Re: **Ziggis Coffee**
5200 Menaul Blvd NE
Traffic Circulation Layout
Architect's Stamp **06-04-2021 (H18-D073)**

Based upon our discussion on resubmittal dated 08-19-2021, the above referenced plan cannot be approved for Building Permit until the following comments are addressed:

TRAFFIC CIRCULATION LAYOUT
APPROVED

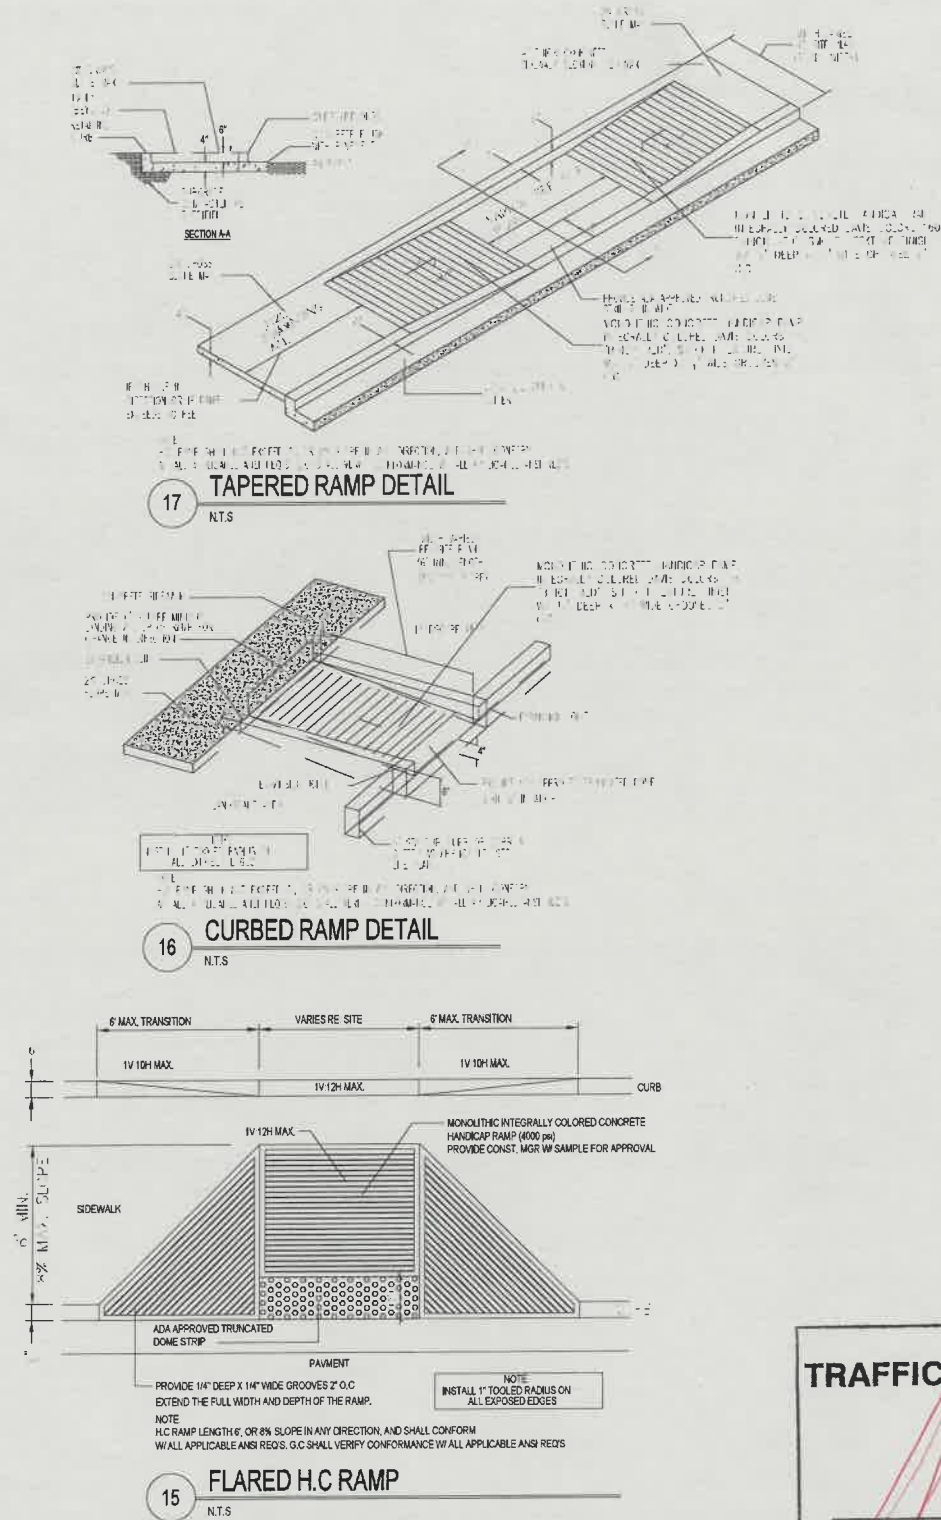
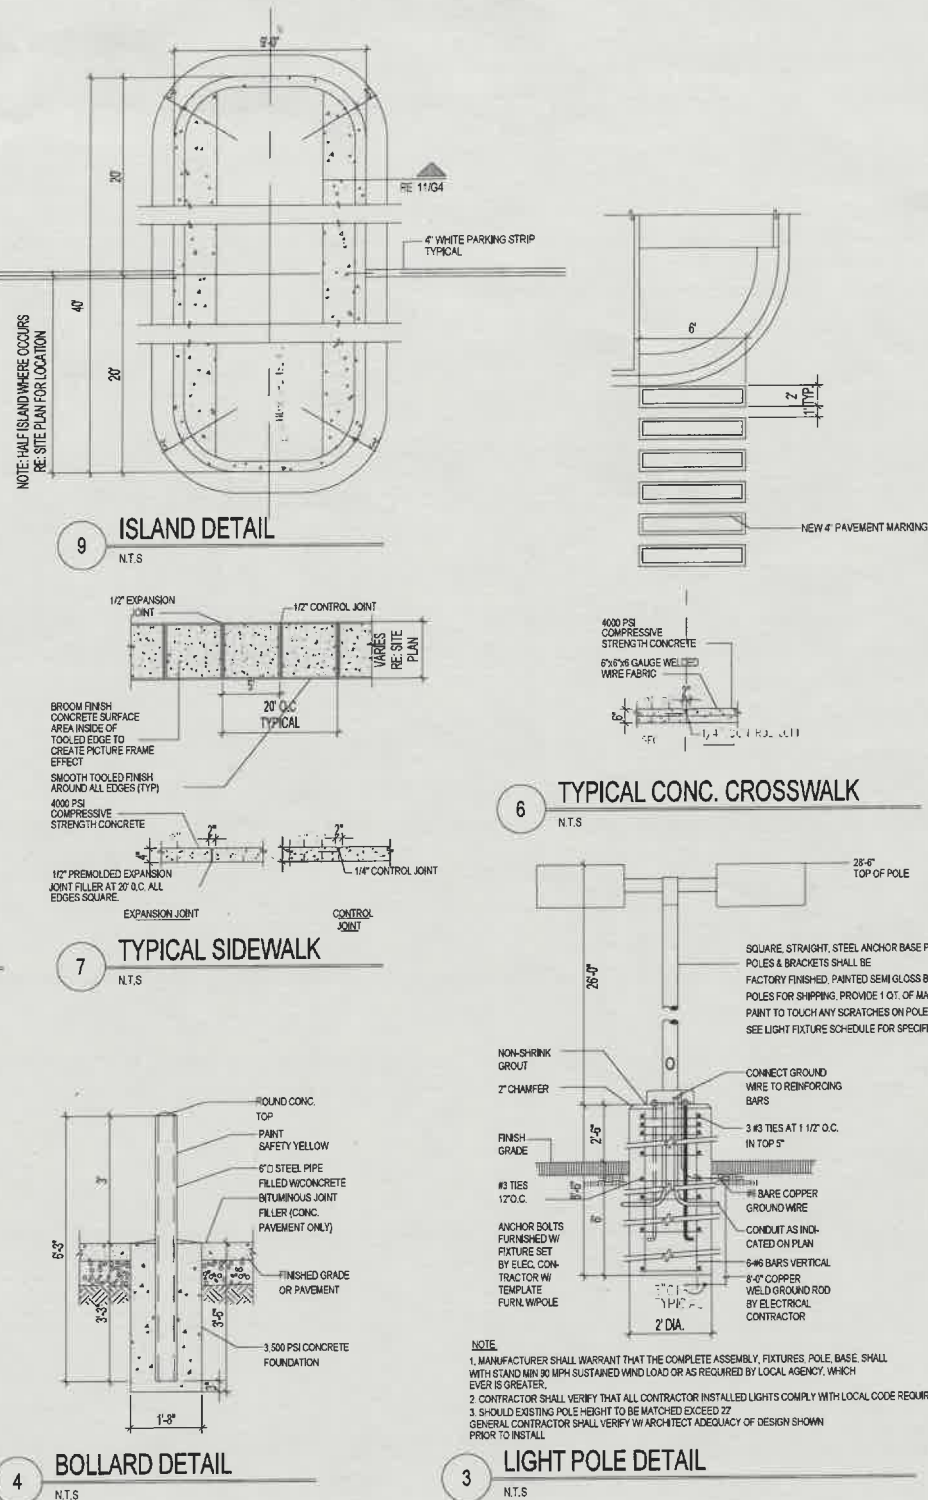
2. **Manual entrance/roadway segment (see G3):**

- The eastern portion of the proposed ramp 12:1 max segment begins at end of radii. So you will need the adjacent land owner permission to accomplish construction on his property **OR MOVE PROPOSED ENTRANCE FURTHER WEST TO AVOID ENCROACHMENT/CONFLICT WITH ADJACENT LAND OWNER'S PROPERTY.**
- **The above comment will need to be addressed prior to TCL project APPROVAL.**

PROJECT TITLE ZIGGIS COFFEE		JOB NO. 5200 MENAUL BLVD. NE ALBUQUERQUE, NM	
PROJECT MANAGER Project Manager		DRAWN BY: Project Manager	
SHEET TITLE SITE DETAILS		SHEET NO. G6	
DATE 06-04-21	SCALE	SHEET

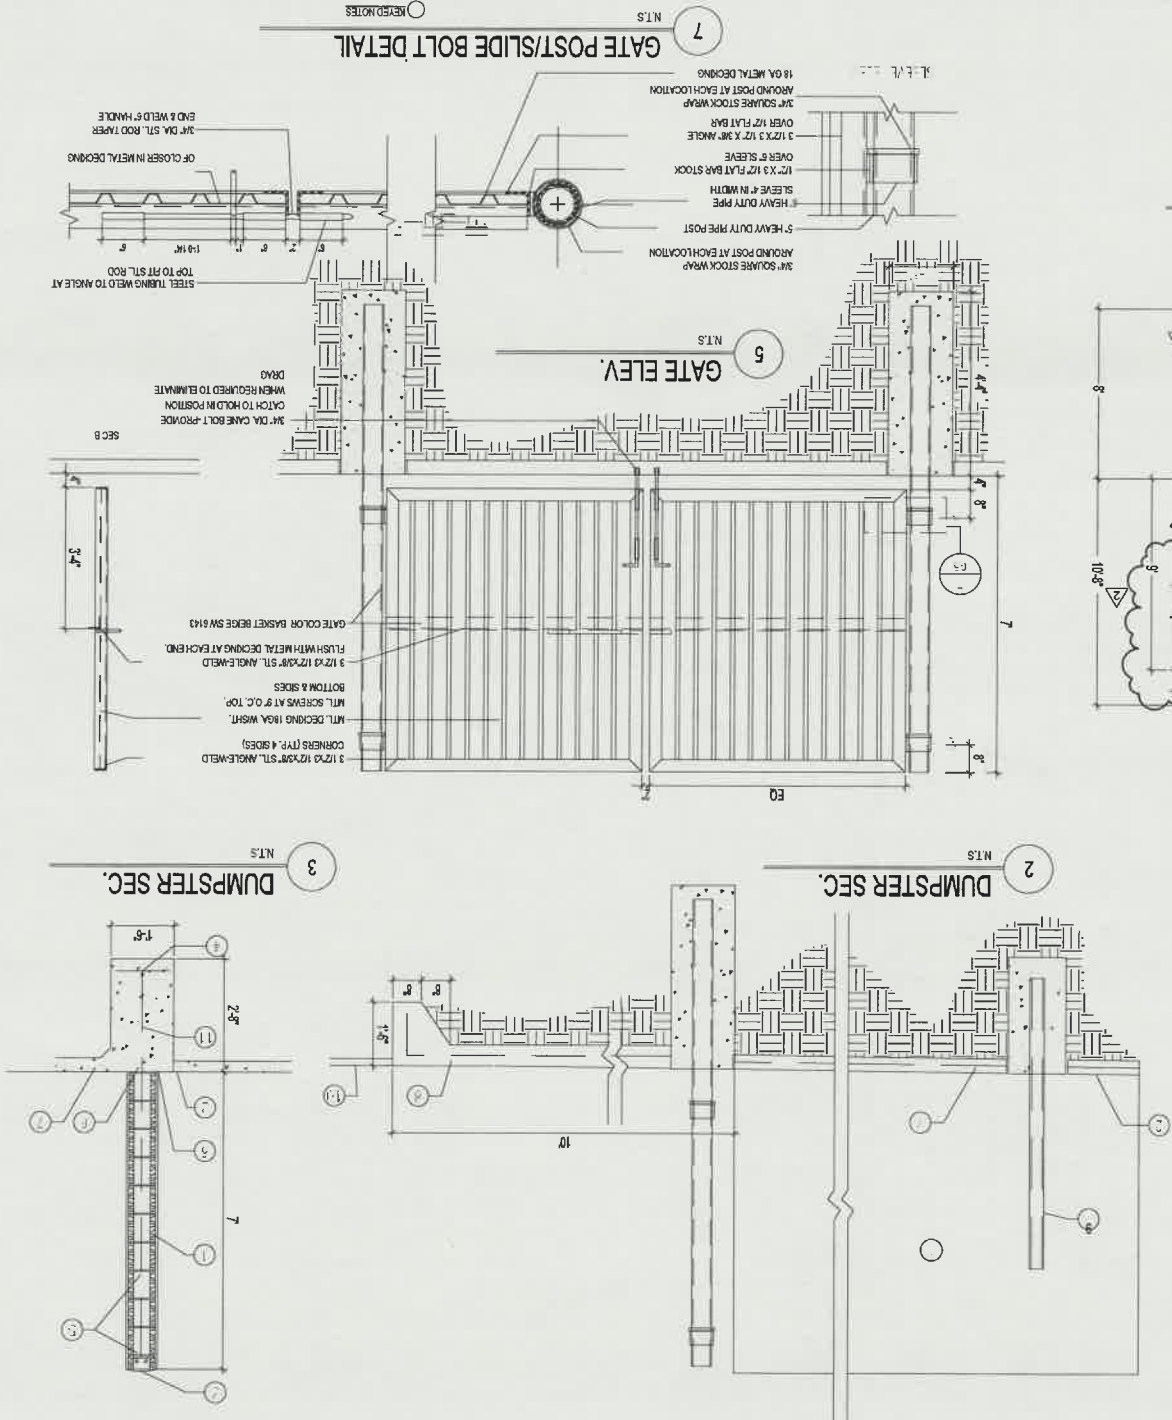
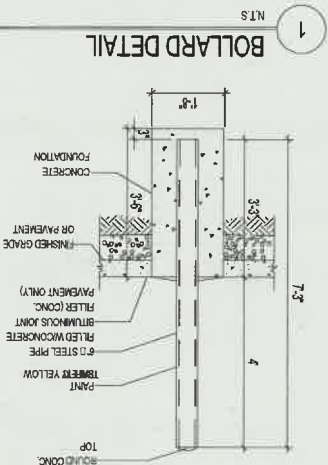
- Add signage as shown on attached exhibit. Use R3-2 & R6-1 at San Mateo median in front of proposed entrance (see G3 & G6).
- Add R5-1 on both sides of entrance facing outward (see G3 & G6).
- Add R3-2 & R6-2 facing inward (see G3 & G6).
- **The above 3 comments could not be review since Sheets G3 and G6 were not provided. Please provide these sheets for review.**
